# OXFORDSHIRE COUNTY COUNCIL'S RESPONSE TO CONSULTATION ON THE FOLLOWING DEVELOPMENT PROPOSAL

**Application no:** 22/01683/F

**Proposal:** Development within Use Classes E (g) (i), and/or (ii), and/or (iii), and/or B2 and/or B8 and Associated Works including Access and Parking

**Location:** Unit 7, Oxford Technology Park, Technology Drive, Kidlington, OX5 1GN

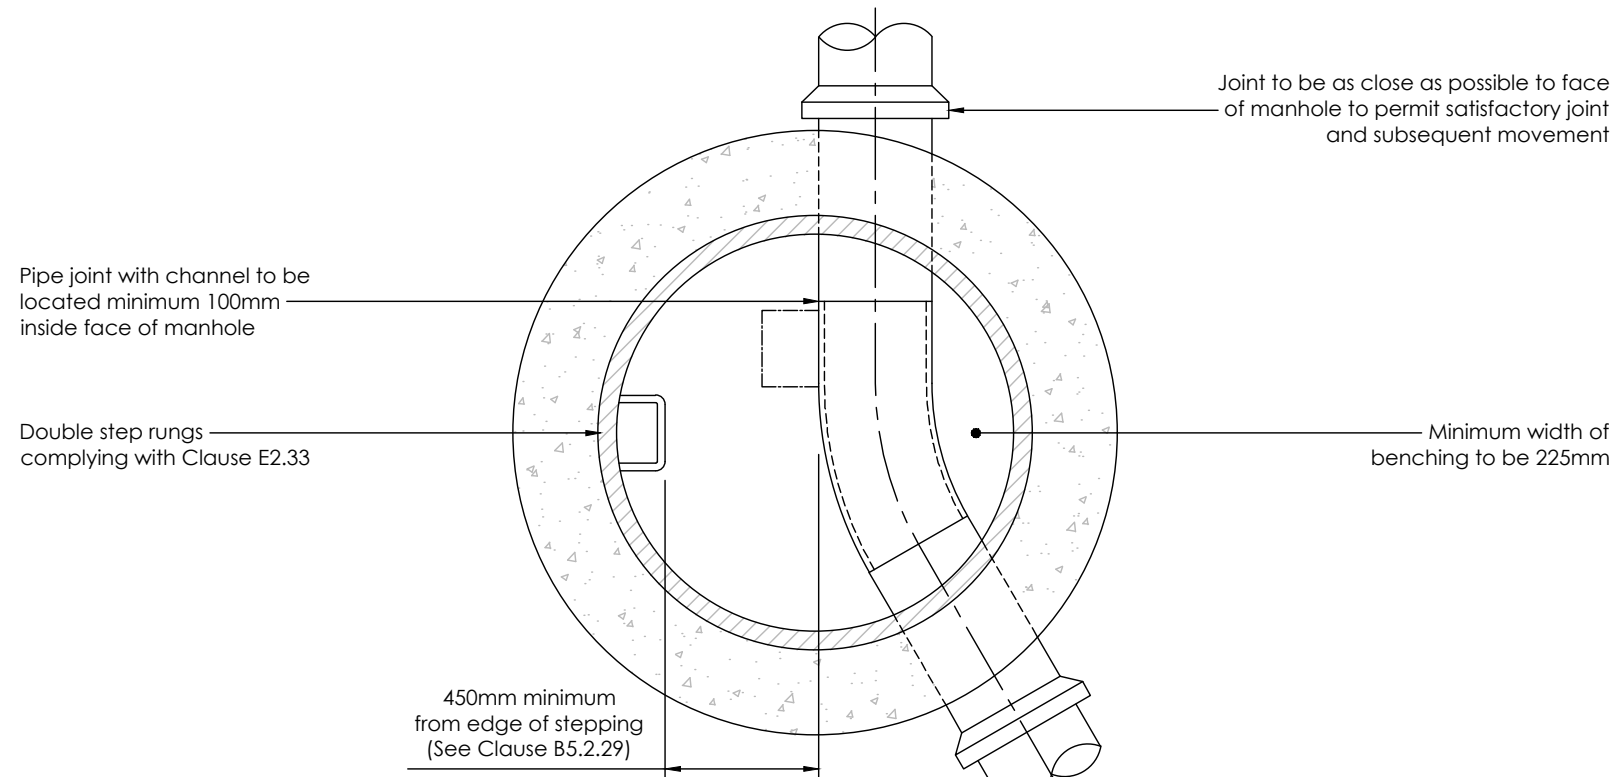
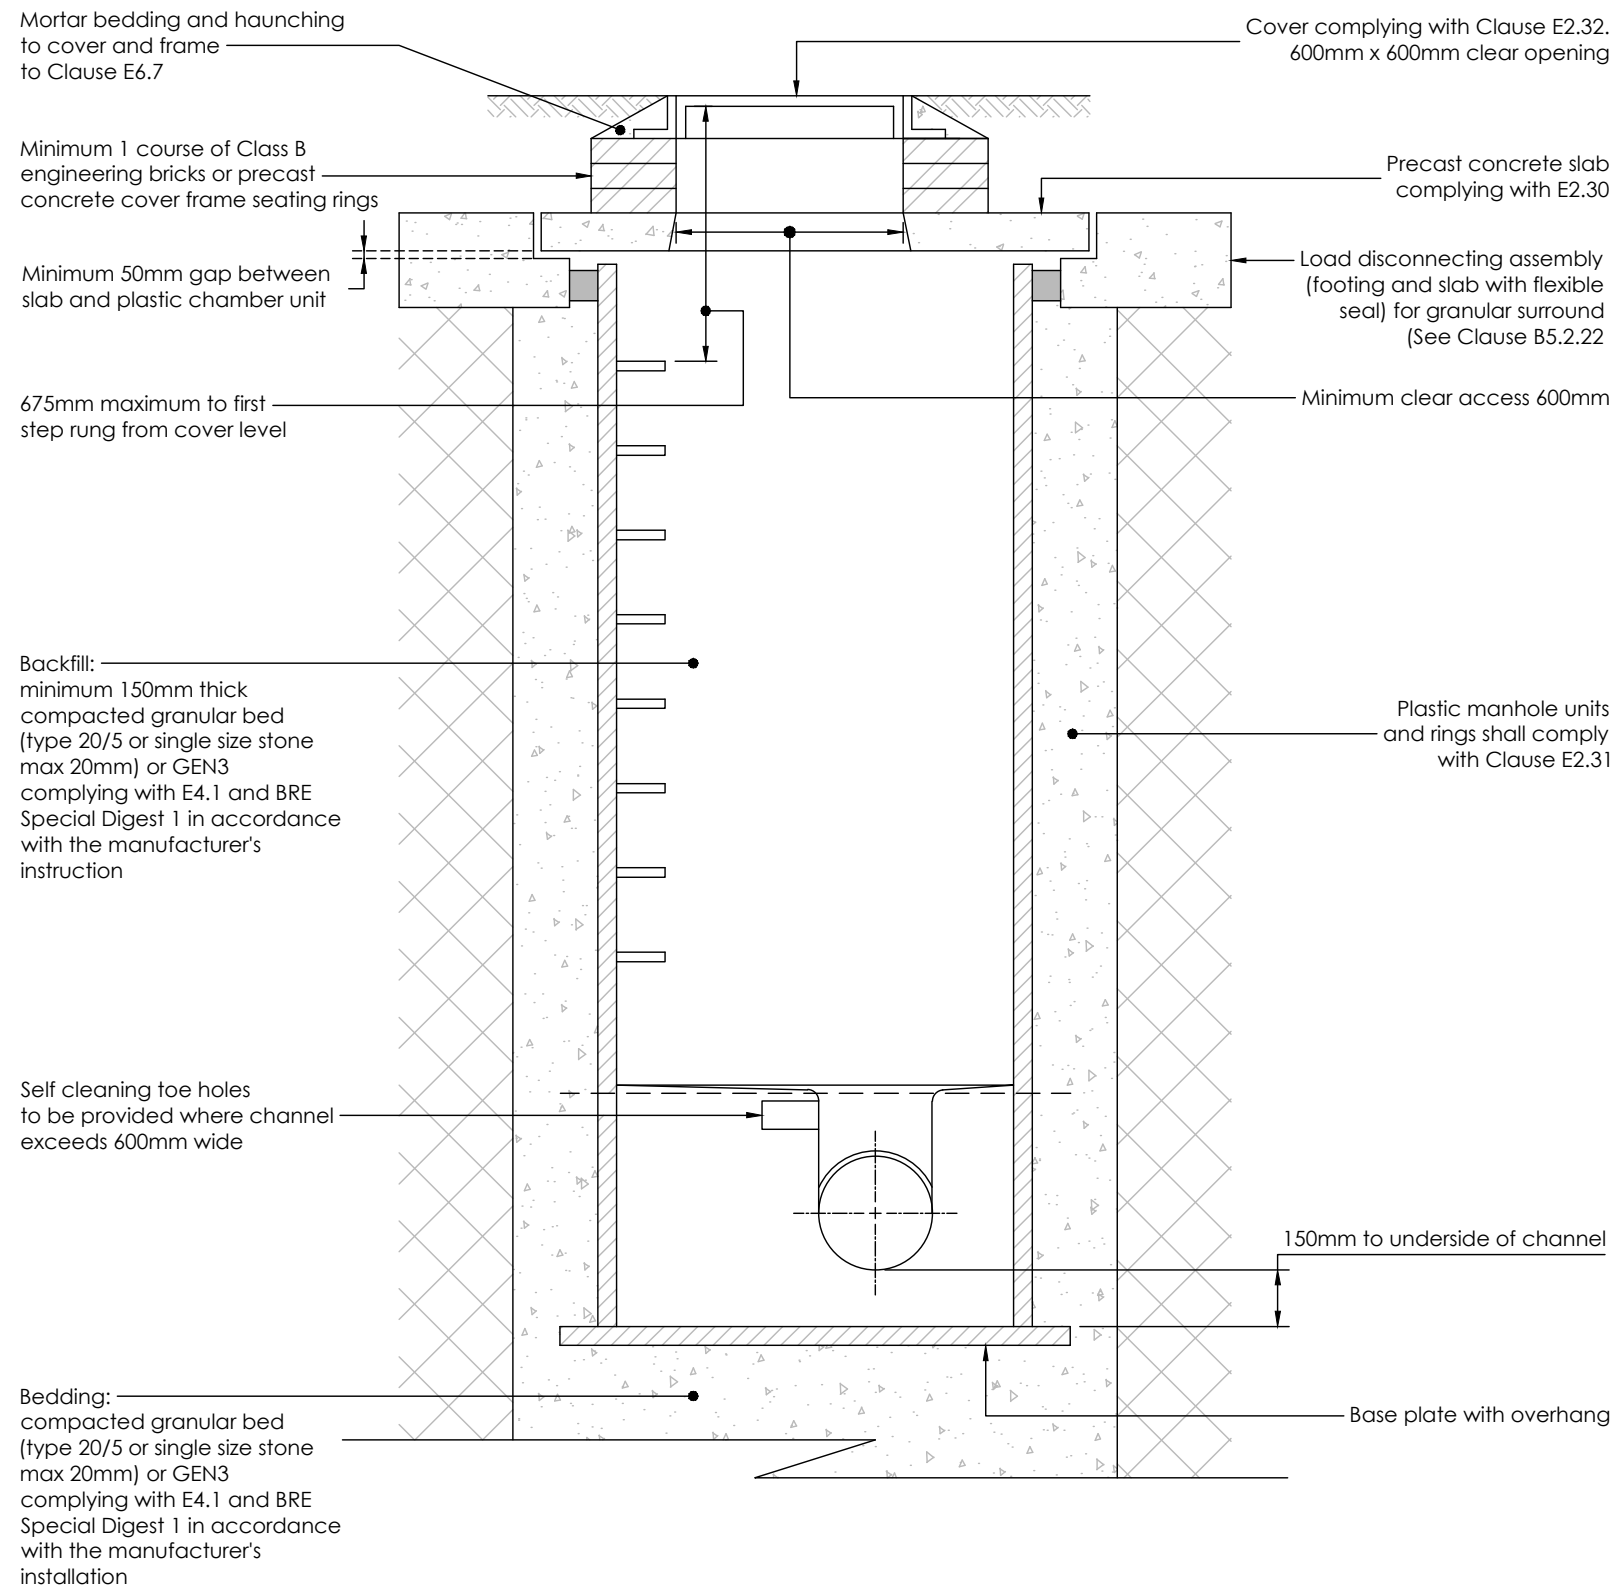
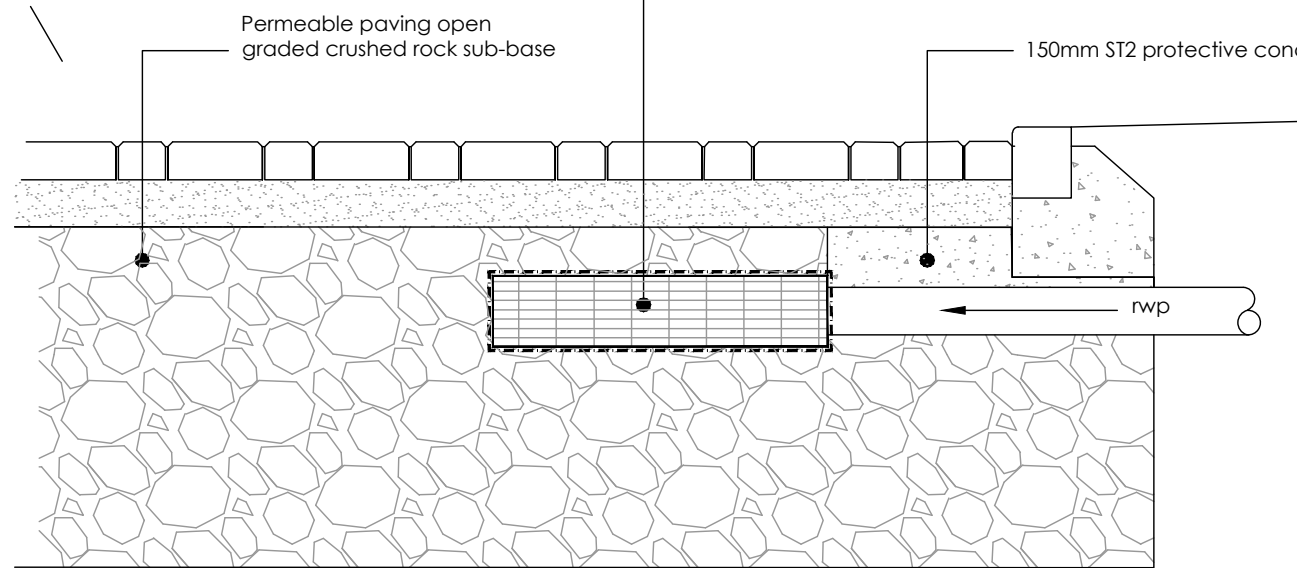
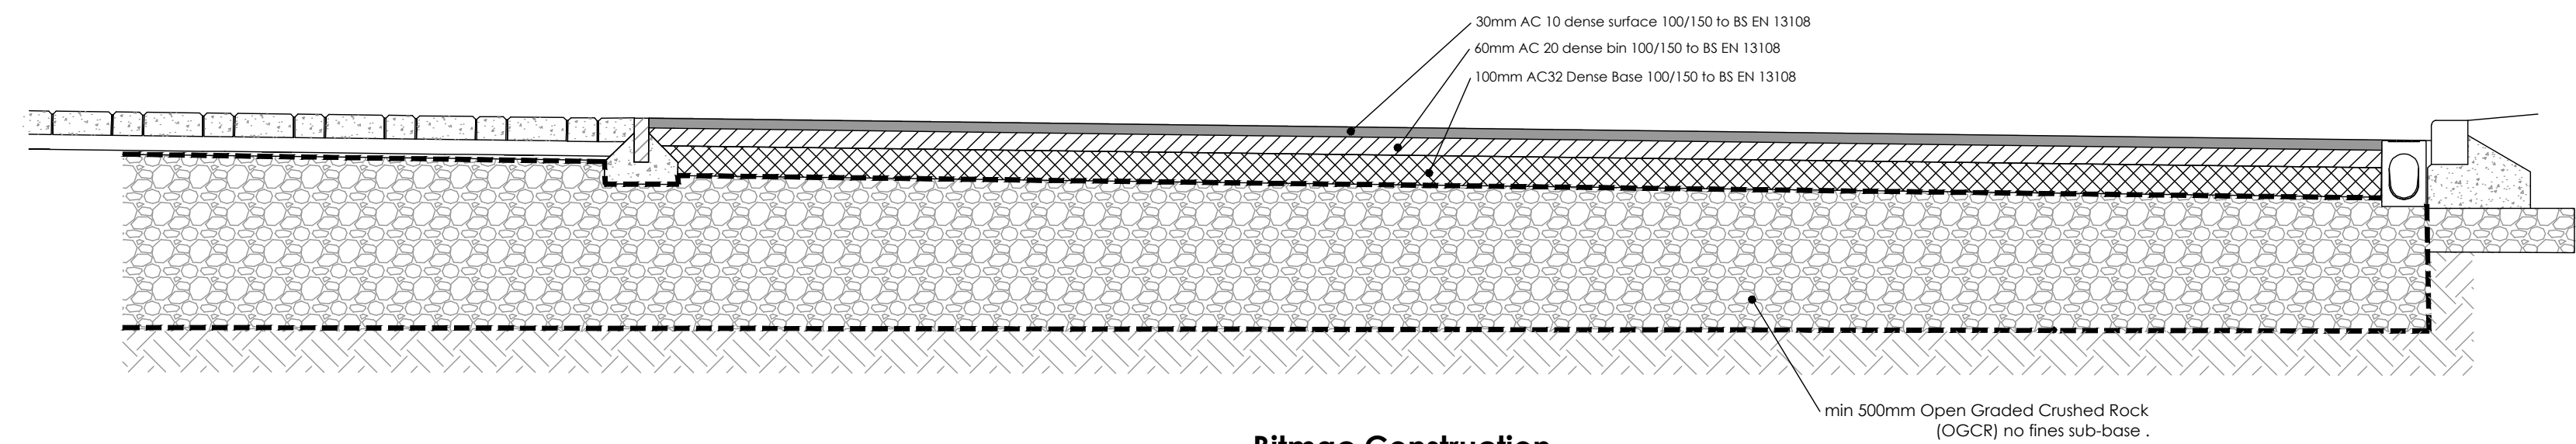
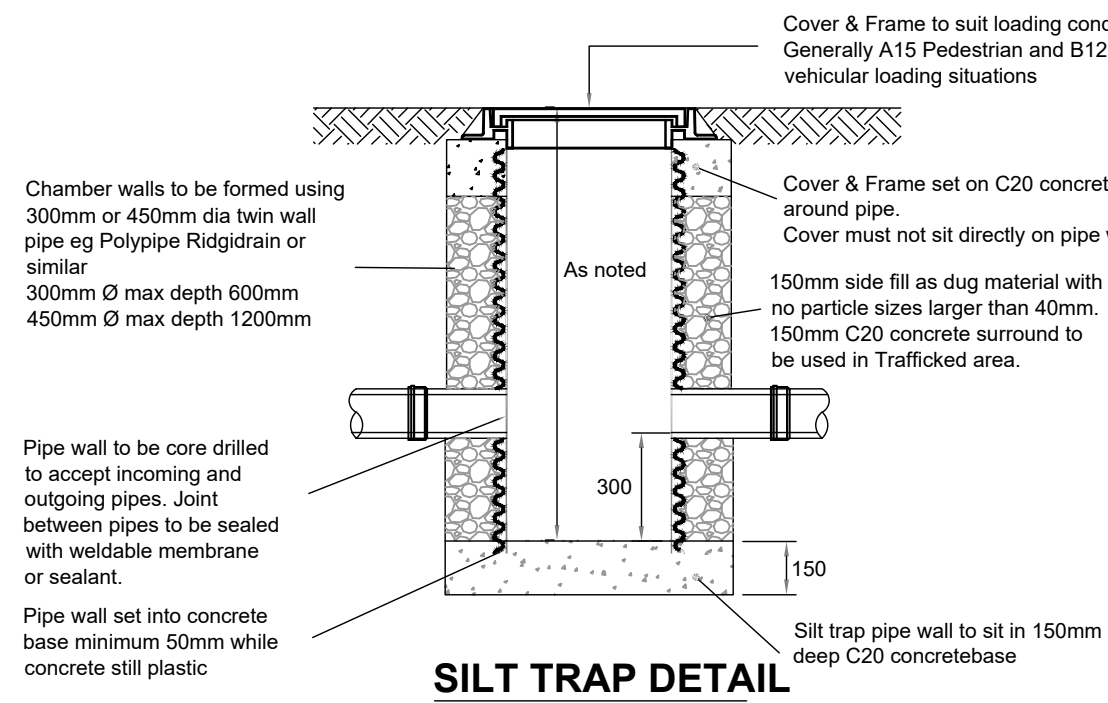
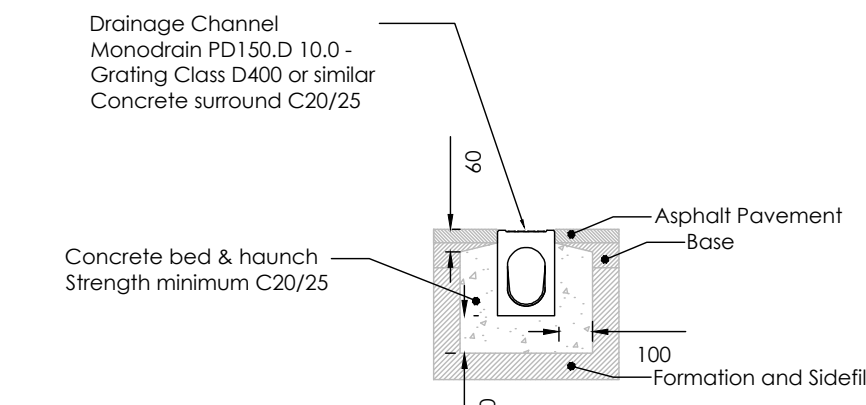
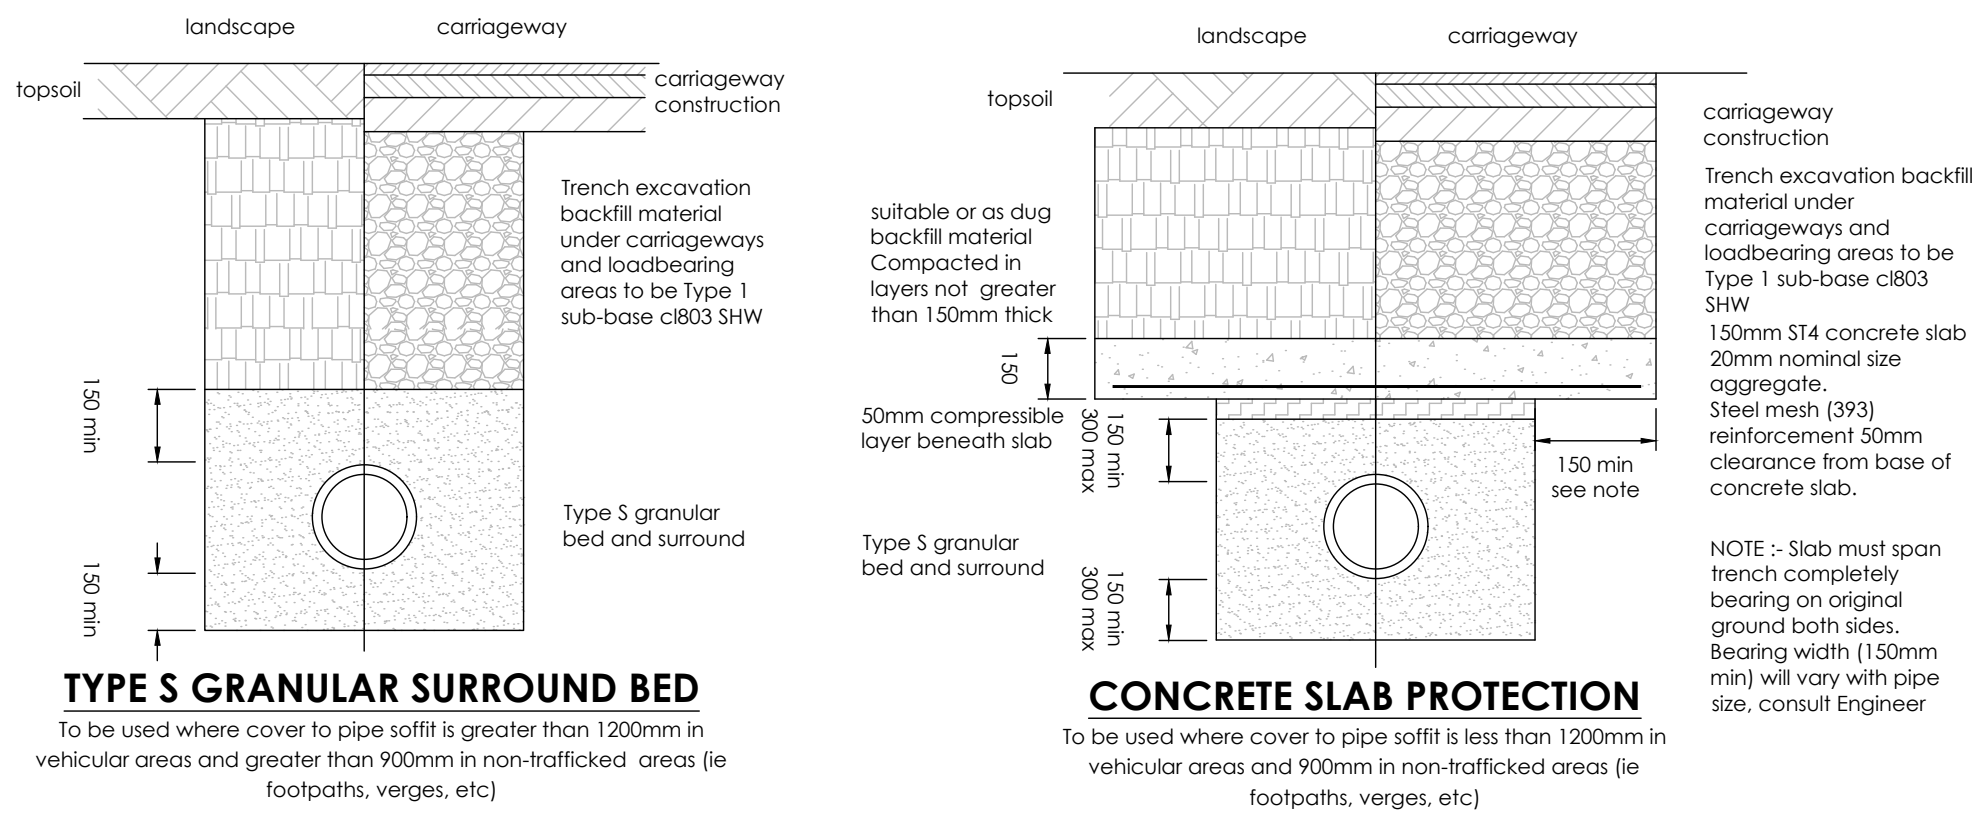
Provide SuDS construction details.
